# WISWELL PARISH COUNCIL

**Planning Application No: 3/2012/0002**  
**Proposed replacement dwelling**  
**Pepper Hill, Pendleton Road, Wiswell, BB7 9BZ**

4206 -04 A-

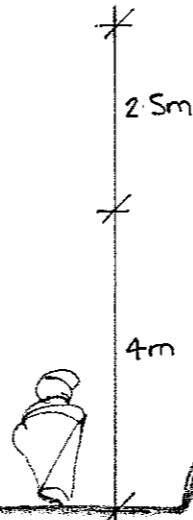
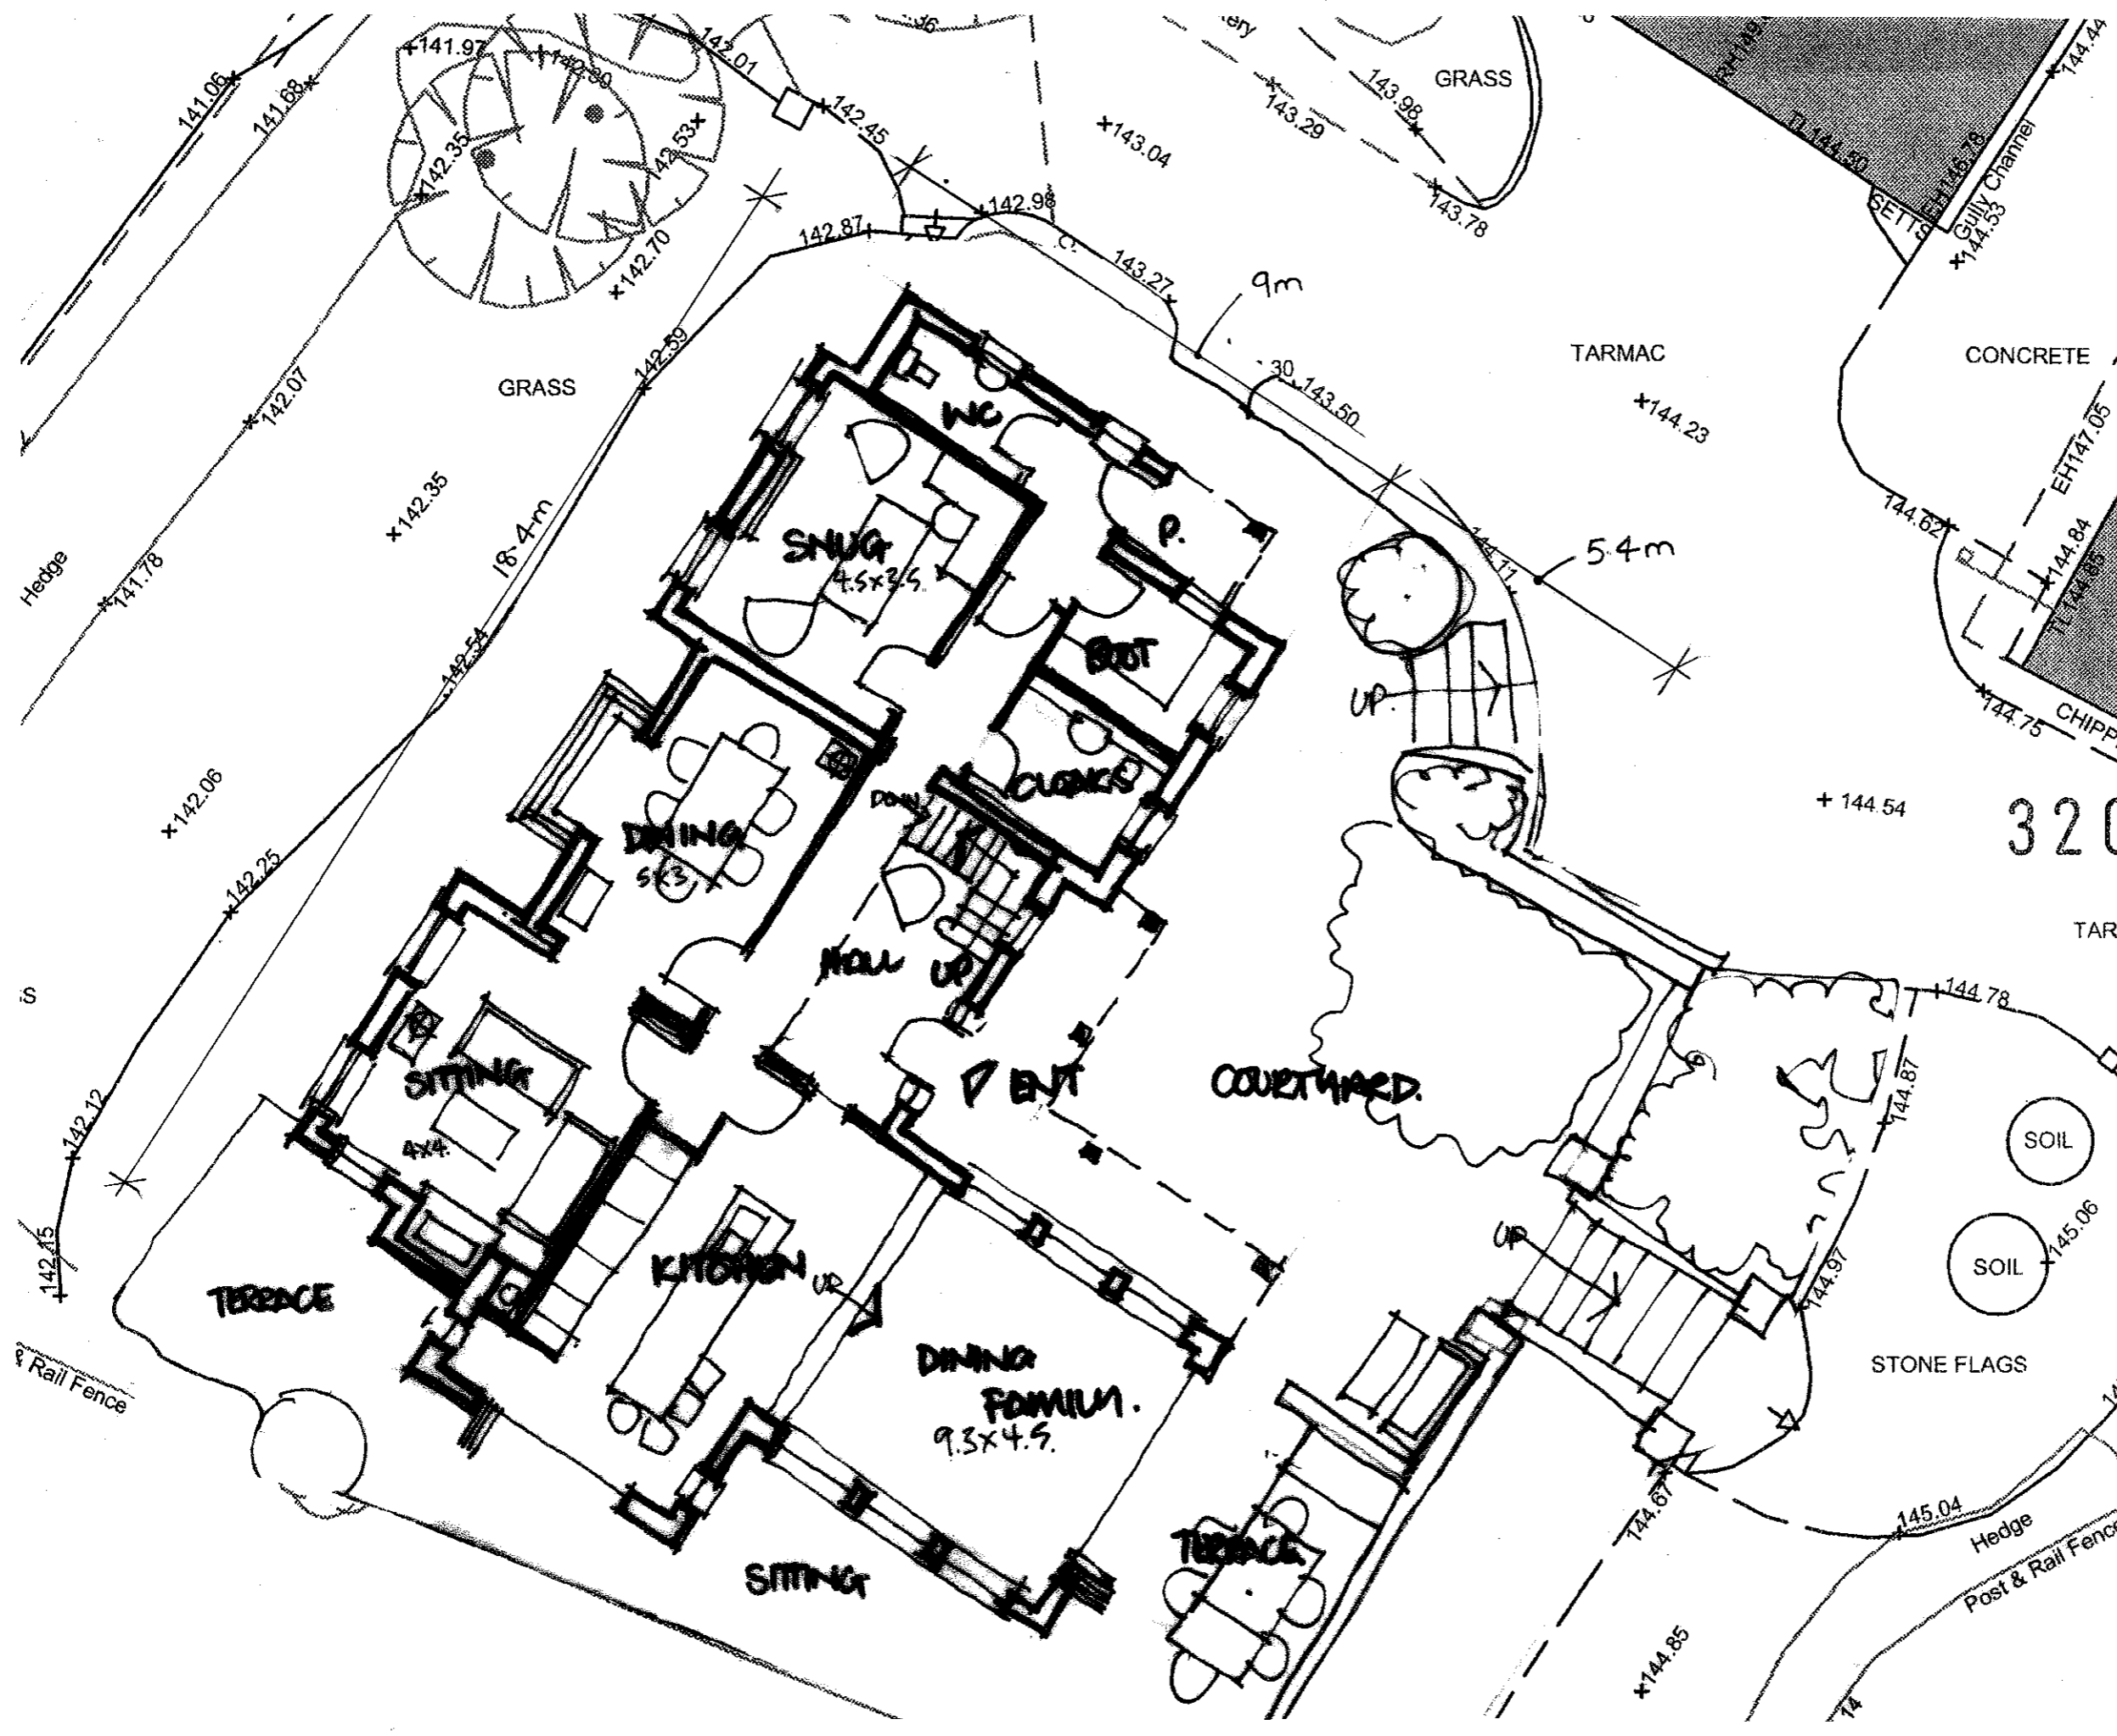
The above application has now been considered by members of the Parish Council. The Councillors welcome the 1½ storey design which is in keeping with the adjacent properties of The Eaves and Kemple View but object to the gables on the north elevation (plan 4206-04) facing Pendleton Road which are an obstructive feature and will have a detrimental impact on the street scene.

In addition, the Councillors request that the exact level of the finished ground floor is clarified before the application is determined and a condition is included to ensure that the level is linked to the spot height and contour shown on the north elevation (plan 4206-04). This will ensure that when the proposed property is built, it meets the relations of the levels on the site.

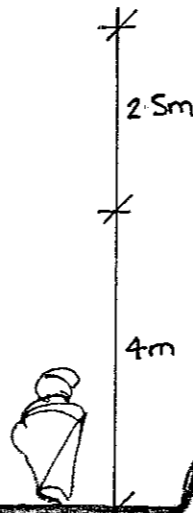
The Councillors also wish to point out the inaccuracy of the elevations on the plans with regard to true North.
